Our Ref: SJB/nm/21046_01

22 October 2021

TOWN AND COUNTRY PLANNING ACT 1990
APPEAL BY MS PARAMJIT SIDHU
279 SWAKELEYS ROAD, ICKENHAM UB10 8DR
APP/R5510/W/21/3282070

DRAWING NO: SR/1000/CP	REVISION: A	ISSUED TO: RICHARD MORTON, PARAMJIT SIDHU
DATE: 31-08-2021	DRAWN BY: MM	
SCALE: 1: 100 on A0	CHECKED BY:

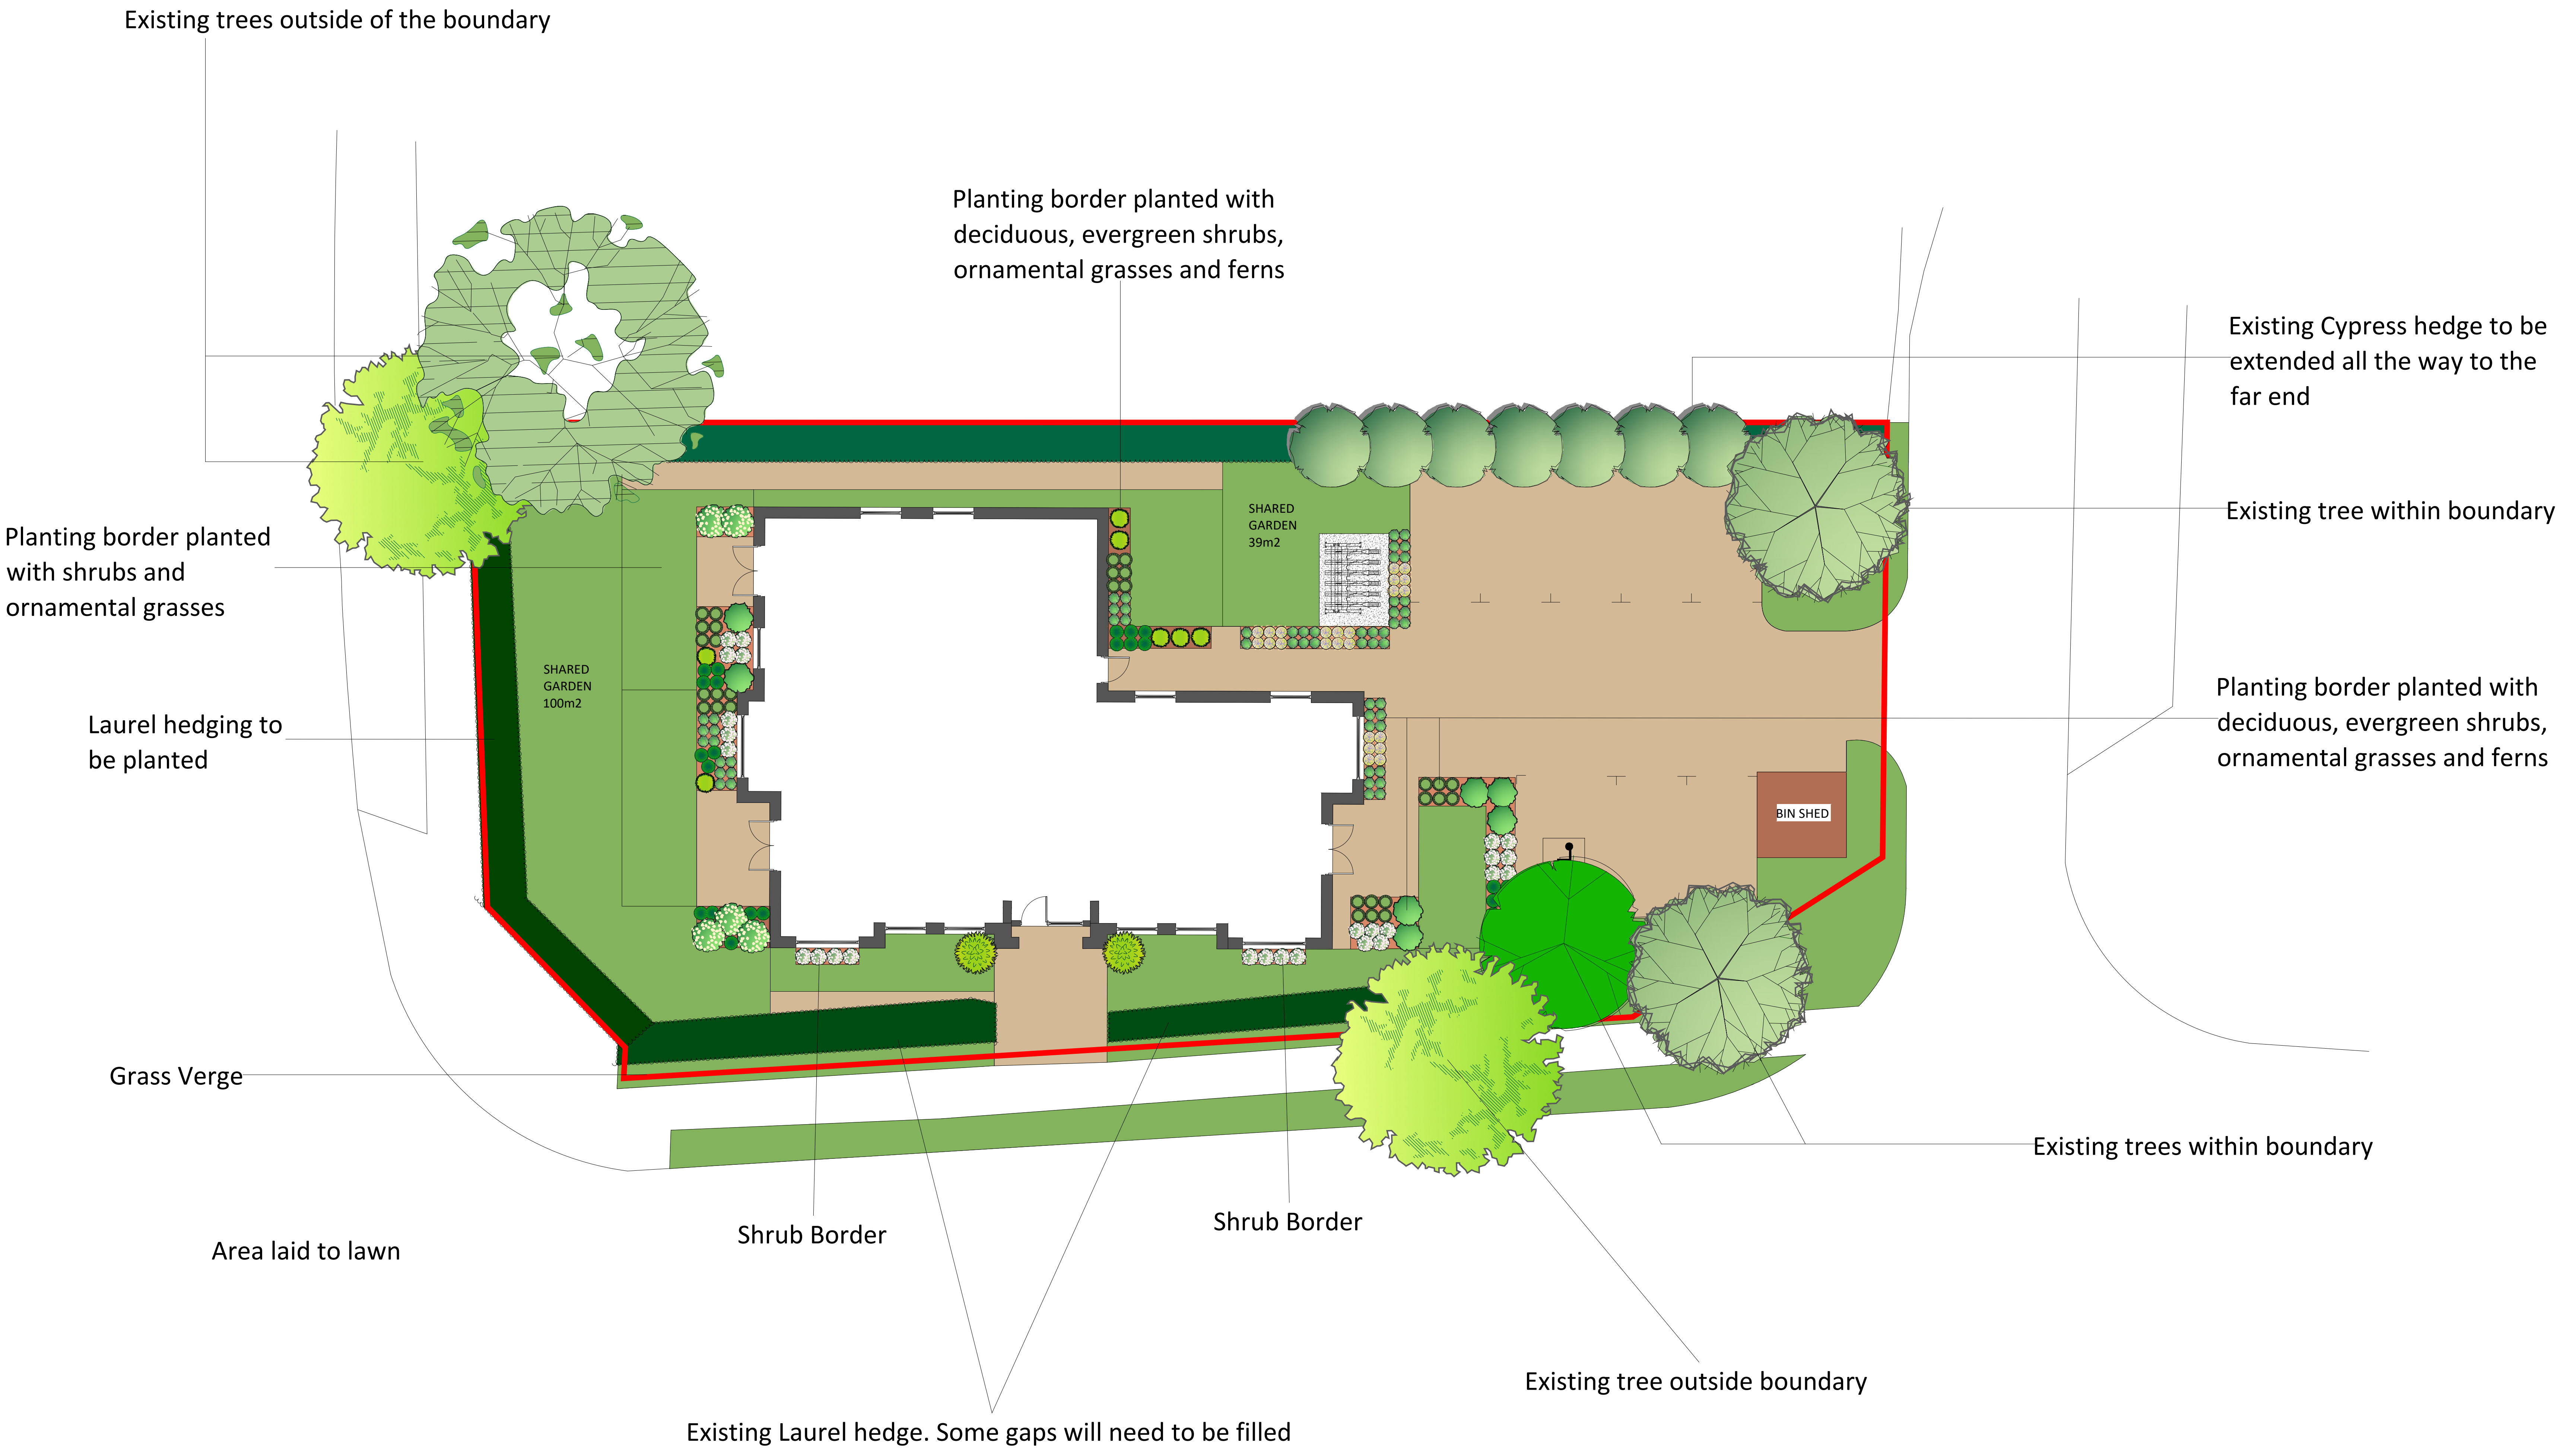
What has happened in preparing revisions to some of the other ‘flat’ plans (ie those portraying the site as opposed to the elevations of the proposed building), is that two of those revisions mis-draw the redline. The architects apologise for this and any confusion or alarm it may, or actually has, occasioned.

The plans in question are: SR/1000/CP/A (Concept Plan for Landscaping) and 177/113/Revision A and these are reattached showing a redline consistent with **the** redline plan. They have not been given a further revision suffix because the drawing itself and its content remains unaltered. The site layout plan does, however, now have an October 2021 date as opposed to June 2021. There is no requirement that these plans do show a redline, it was carried over onto them to assist. Hopefully this matter is now clarified and the appellant is making no attempt to redefine or enlarge the extent of the site which is, in any event, very clear to see on the ground being bound by fences/walls and highways land on three sides and the boundary fence with 277 Swakeleys Road on the fourth.

Drawing
North & South Elevations
-
-

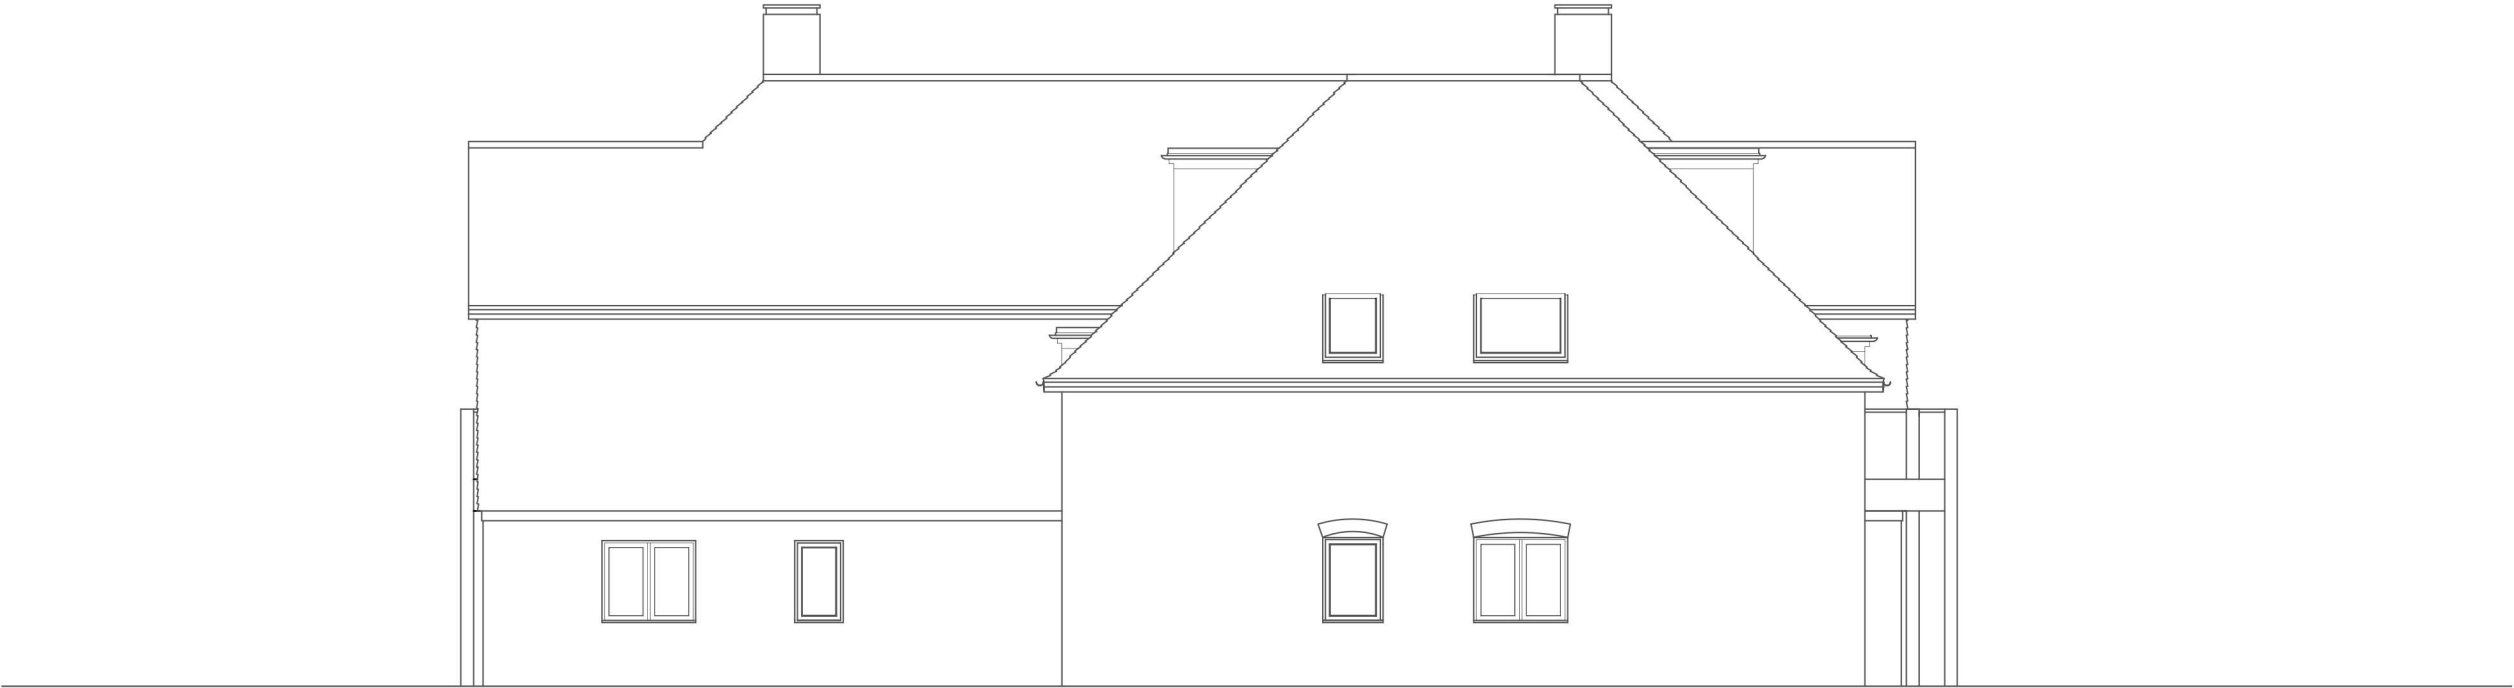
The changes to the roof are addressed above. With regard to the fenestration, should the Inspector not accept the revised plans, there are two alternatives. A condition can be imposed to effectively delete the windows in question (all are secondary) with the following possible wording:

All the elevations are changed, but only to accommodate the altered roof and the deleted windows. The changes not being as great as the Council seems to consider. It is now for the Inspector to decide, but the Council is wrong to suggest that the scheme may only be approved in relation to the submitted plans as its recommended condition No.2 suggests. In other respects, No.9 is referred to above and the others are acceptable although, No.8 appears superfluous as flats do not benefit from normal domestic pd rights.

"Notwithstanding the north-east facing windows in Flats 6 and 7 on drawings _____ revised plans should be submitted and approved showing them removed, etc."

Alternatively, a condition can be imposed to the effect that these windows are obscure glazed and fixed shut prior to first occupation and remain so in perpetuity. Indeed, the LPA has suggested just this (No.9 in its recommended conditions).

Project No.	Drawing No.	Revision
177	113	A

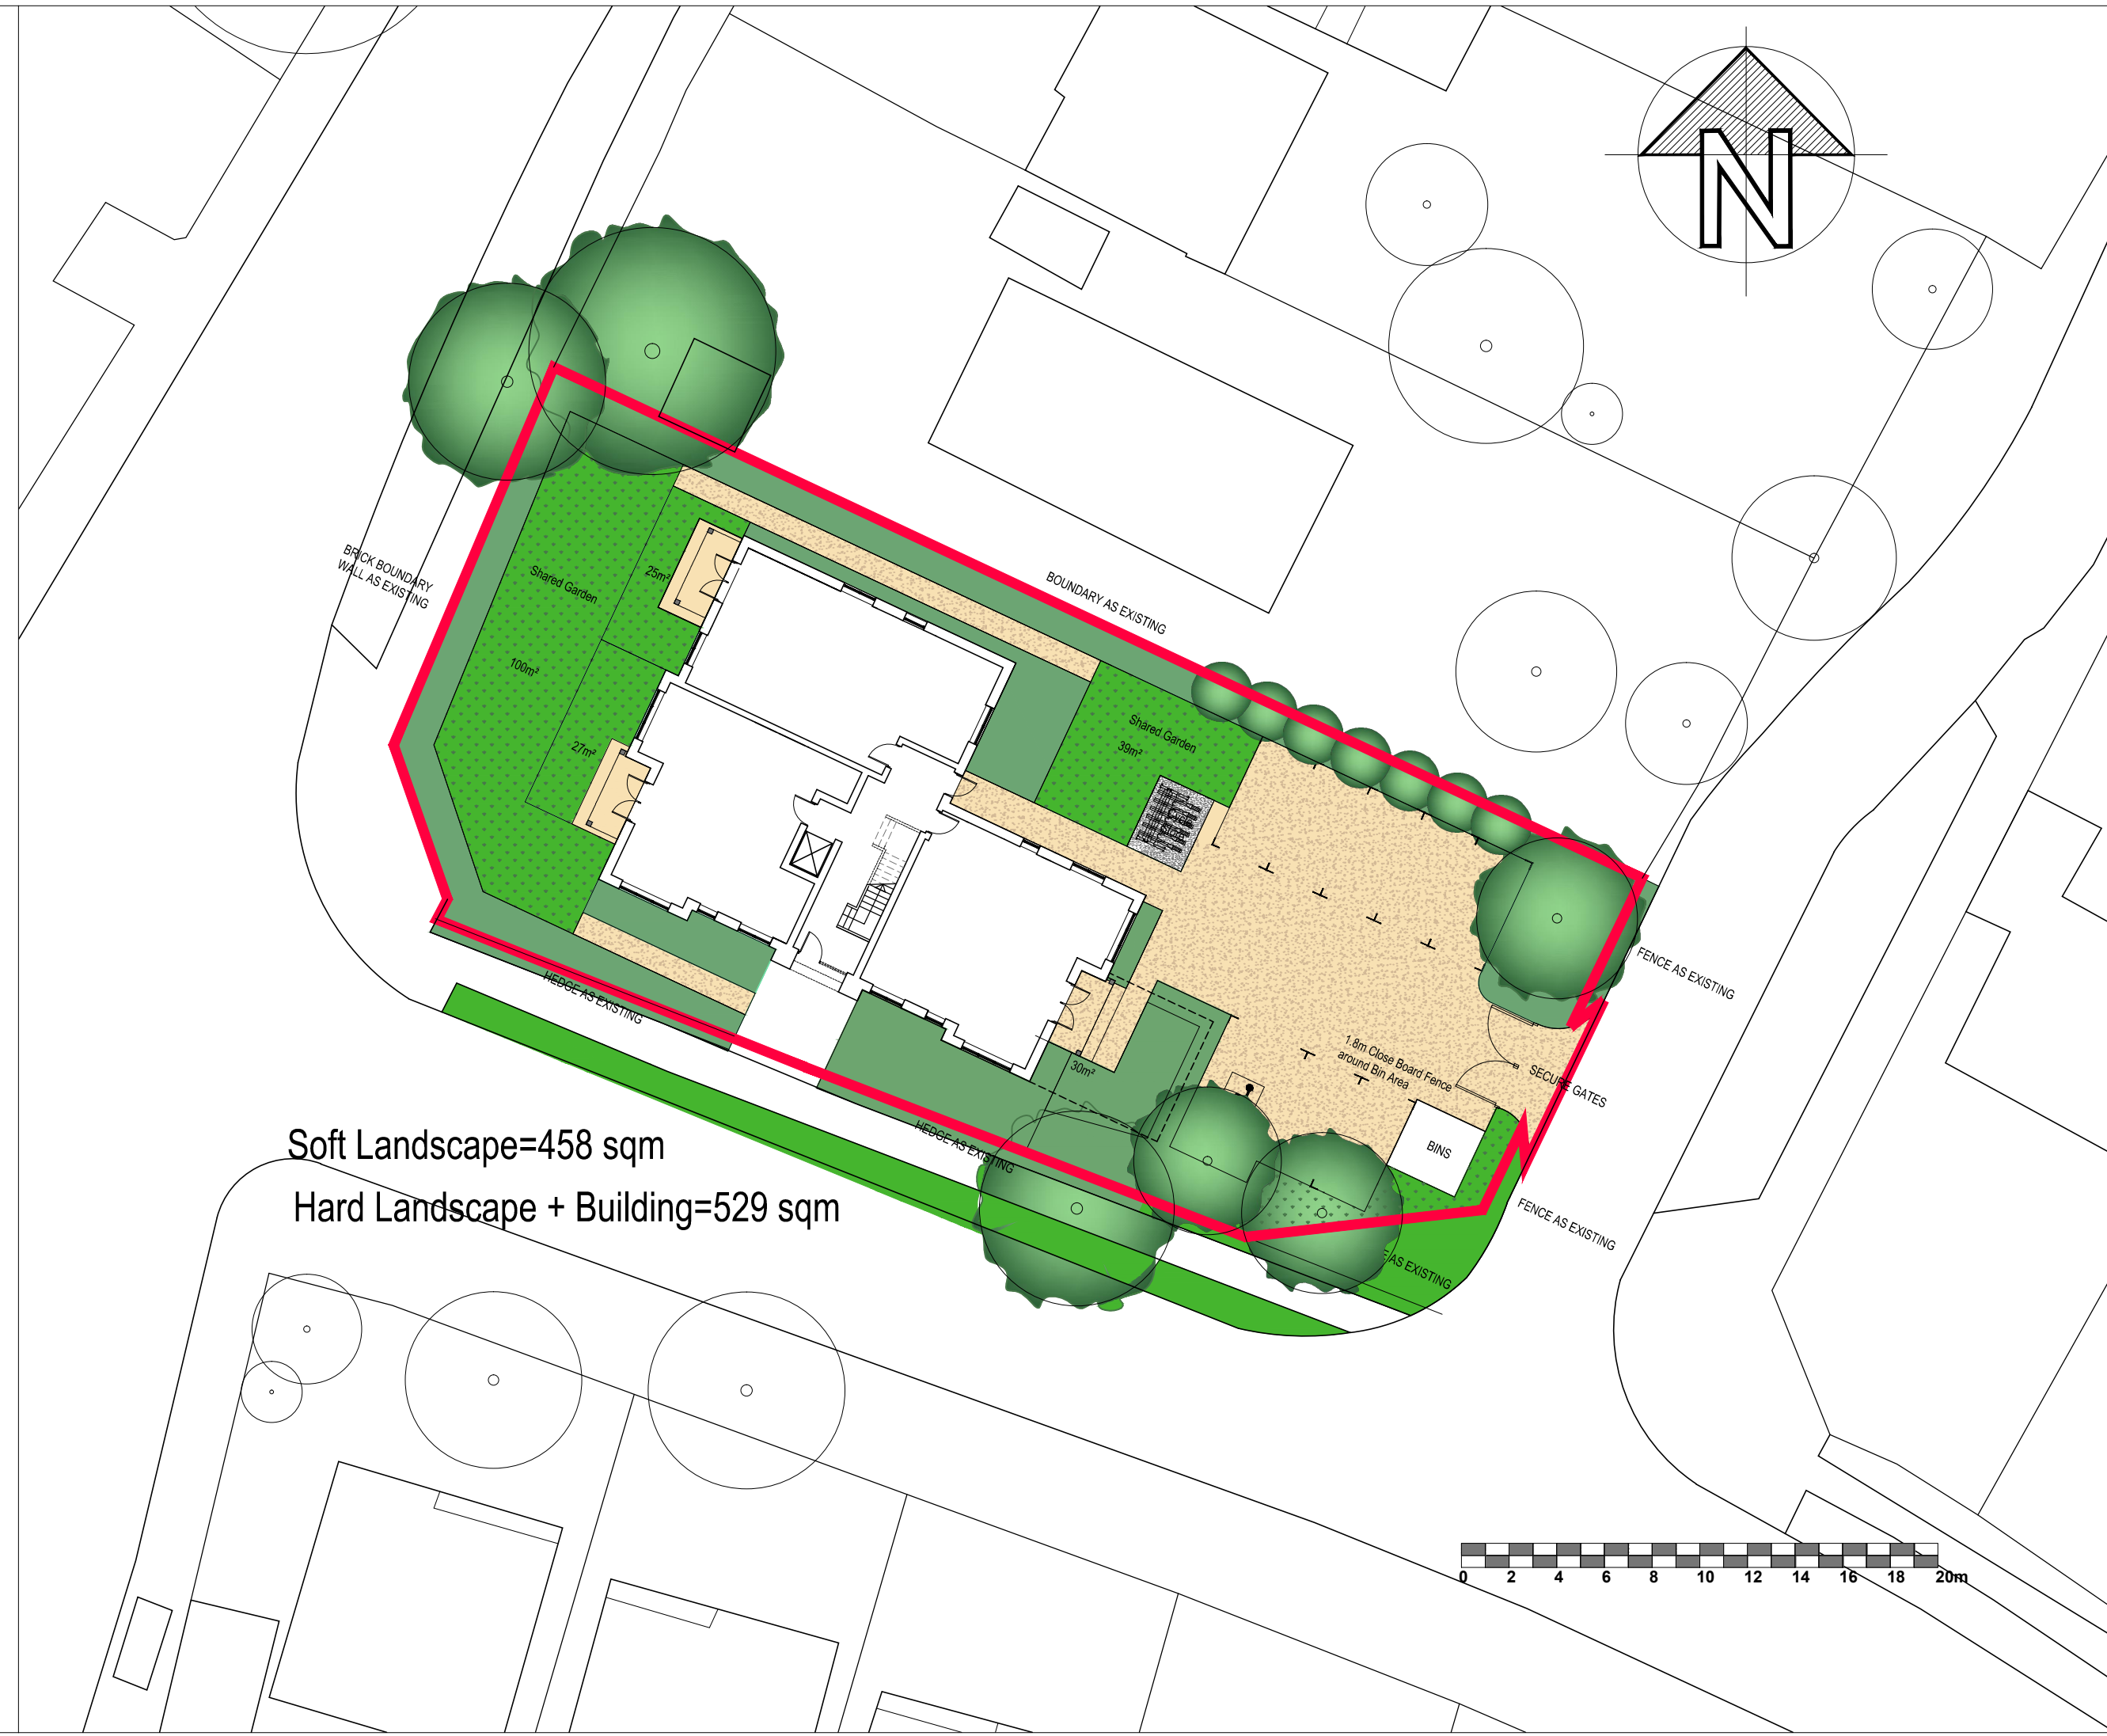
The matter of amenity space was discussed in paragraphs 5.18-5.25 of the appellant's SOC. The *"deficit"* was the amenity space not provided by the balconies to flats 4-6 (first floor) and 7 (second floor). It is indeed 79.5m, but as the revised plans show, in addition to parking, landscaping, paths, bin stores and private ground floor flat gardens, the grounds provide a total of 139m² usable, communal garden, considerably more than is required.
